| Application number: 2025/92713   |  |
| What is the application for?:    | Reserved matters application pursuant to outline permission 2023/92079 for erect |
| Address of the site or building: | Rear of, 23 to 43, Moor Lane, Gomersal, Cleckheaton, BD19 4LF                    |

PLOTS 10

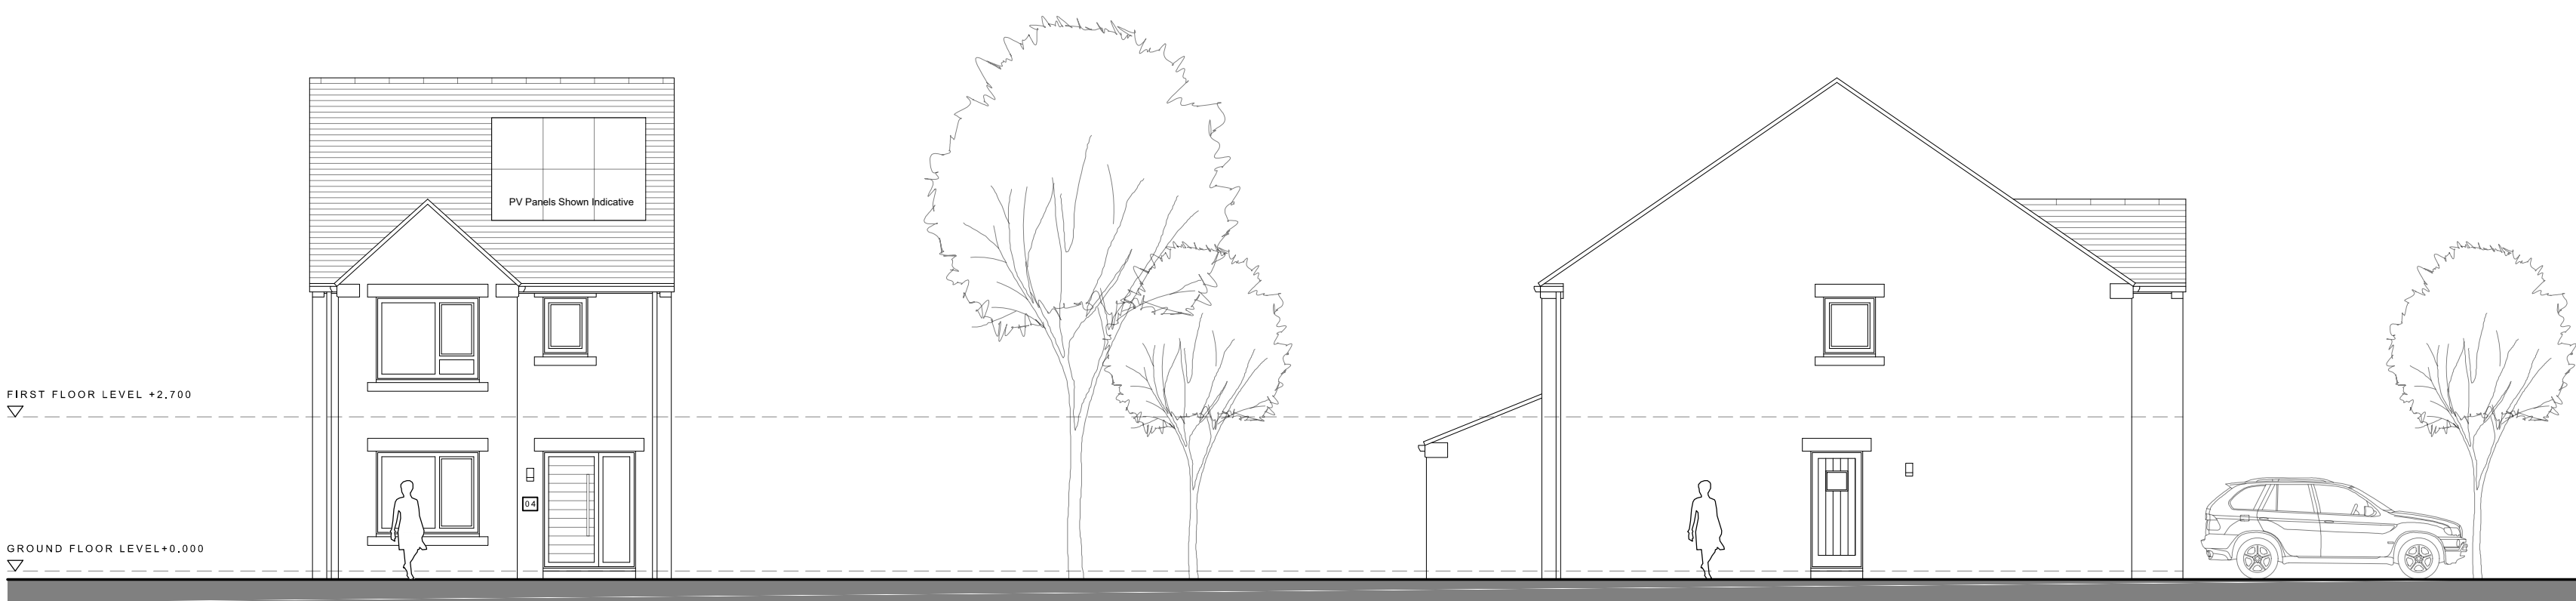
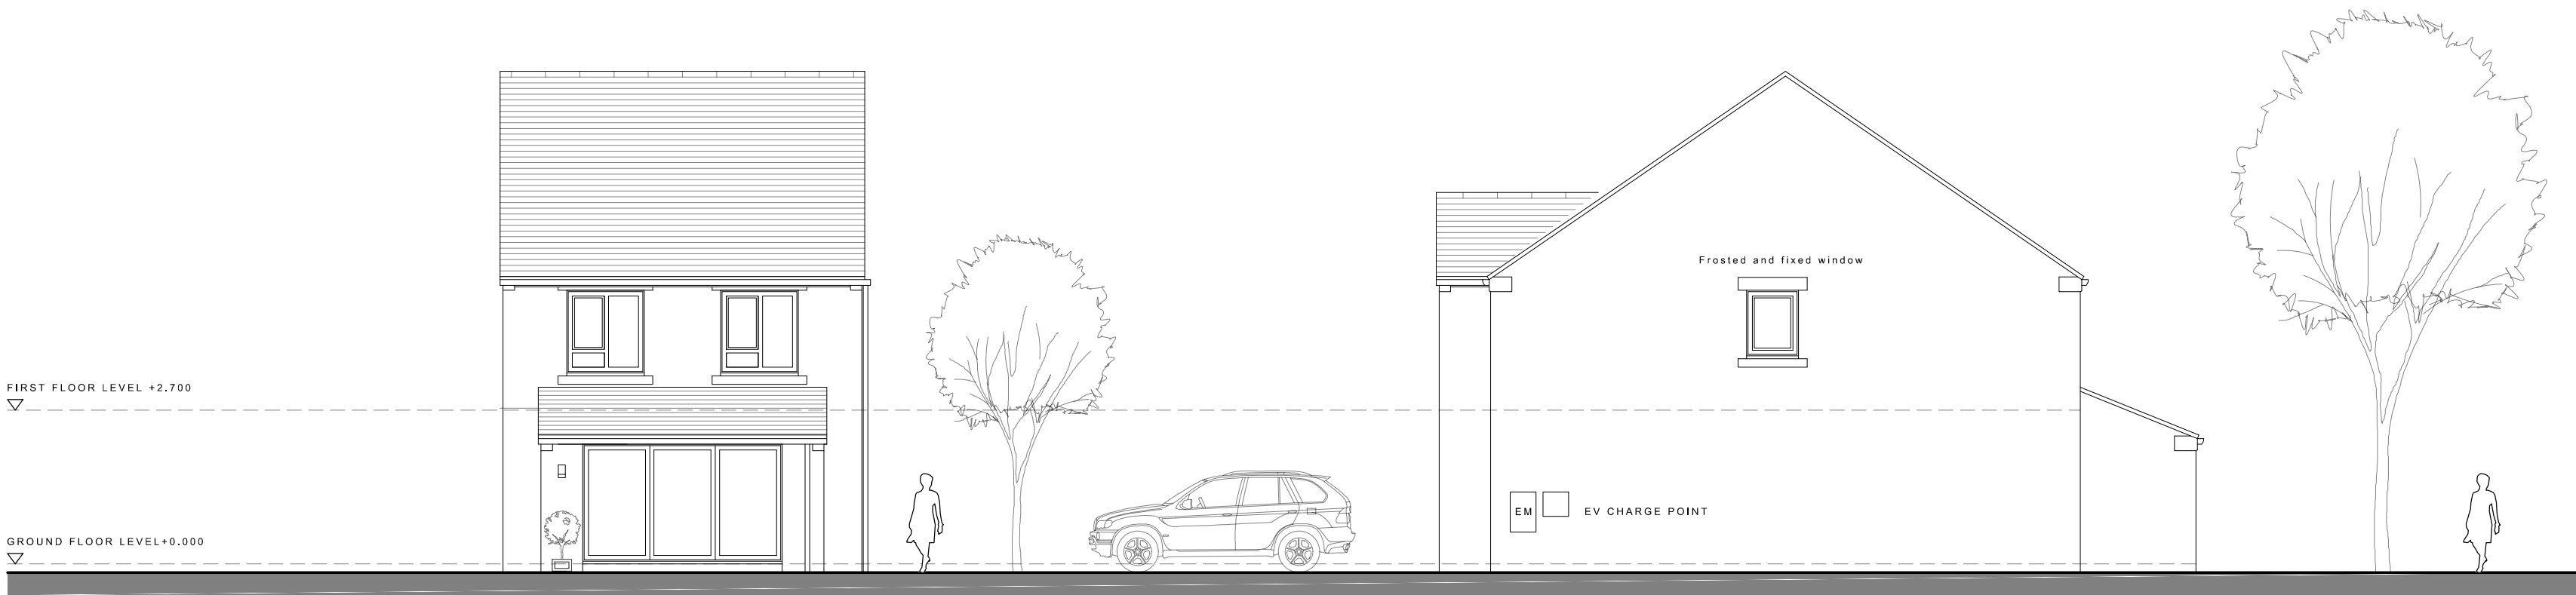
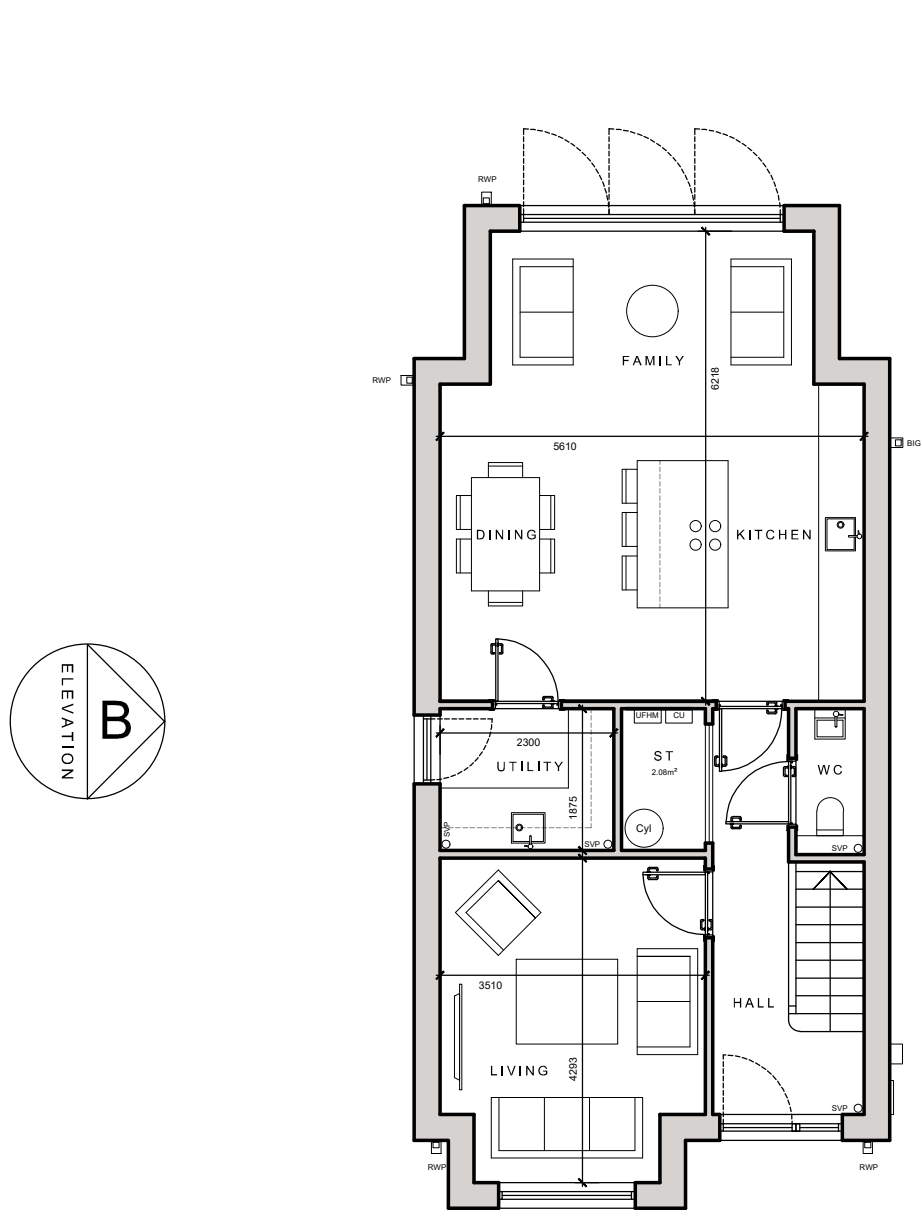
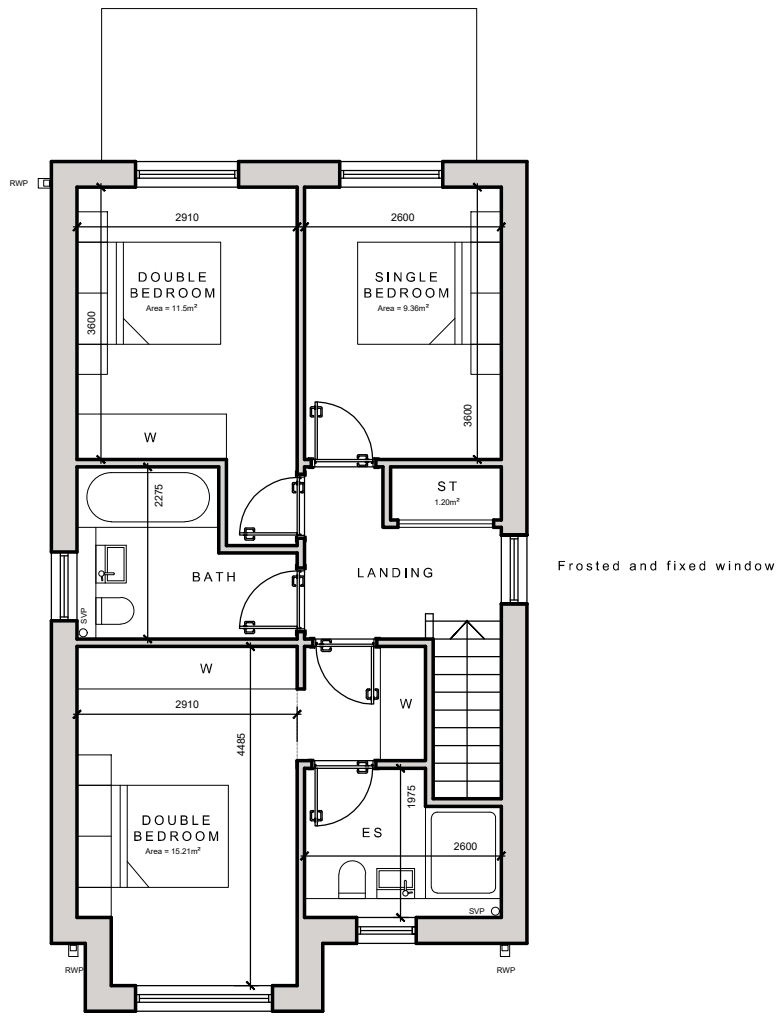
In the final design on planning application No 2025/61/92713/E Plot 10 has two non habitable windows and an entrance doorway in the wall which overlooks

This garden sits on the boundary of this proposed site where Plot 10 will be located. Plot 10's house wall, which includes the two non habitable windows and an entrance door, will run along this boundary and will only be 7 metres away from this habitable window.

This conservatory is a habitable room, with all clear glass doors and windows and will be a lot closer to the proposed wall of Plot 10 than the lounge window of which doesn't meet the minimum separations distances specified.

As can be seen, on the plans submitted with this application, the topography of Plot 10 is at least 4 foot higher . This fact means that Plot 10, a large 5 bedroomed house, will be higher and therefore will overlook the house, conservatory and our gardens.

The proposed wall of Plot 10's house is going to overshadow the existing property at the house, the conservatory and the garden, causing loss of privacy and loss of light.

The minimum separation distance between Plot 10 should be 12 metres.
